From: [REDACTED]
To: [A303 Sparkford to Ilchester](#)
Cc: [REDACTED]
Subject: Comments on Applicant's document regarding Sparkford to Ilchester A303 improvements
Date: 26 August 2020 08:20:47
Attachments: [image001.png](#)

I represent the family members and business of Camel Hill Farm, which owns and farms most of the adjacent land north of the A303, between Sparkford Roundabout and Steart Lane. My unique reference is SPIL – SFP137.

Figure 2.8: Changes to highways in the vicinity of Hazlegrove Junction

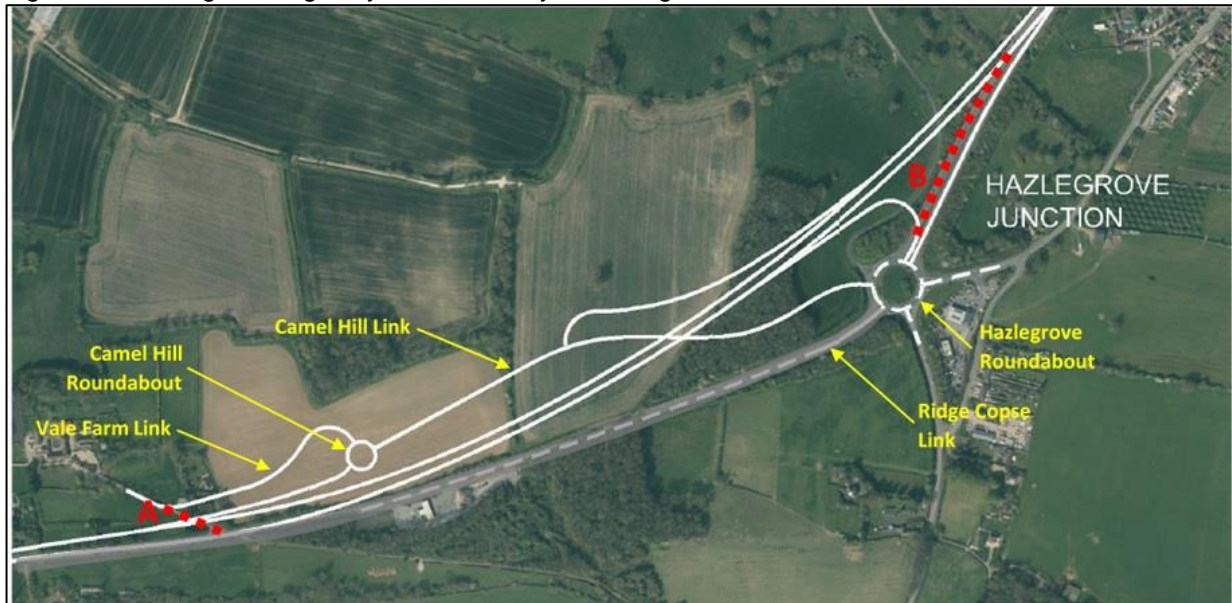
1. Regarding the 'Parallel Local Road' issue discussed in Chapter 6 of the response:
Whilst I am sympathetic to the general principle put forward by the parish; **please do not try to solve this by taking more land to the north of the current A303, or using the lane to our properties at Camel Hill and Vale Farm.** The current proposals will have a huge impact on our properties and the farm business. Our experience so far is that the compulsory acquisition procedure is inadequate in compensating for losses of amenity, time and emotional stress caused by the development. We therefore do not want any further road development on our property. We are not supportive of a Parallel Local Road unless it is to the south of the current carriageway.
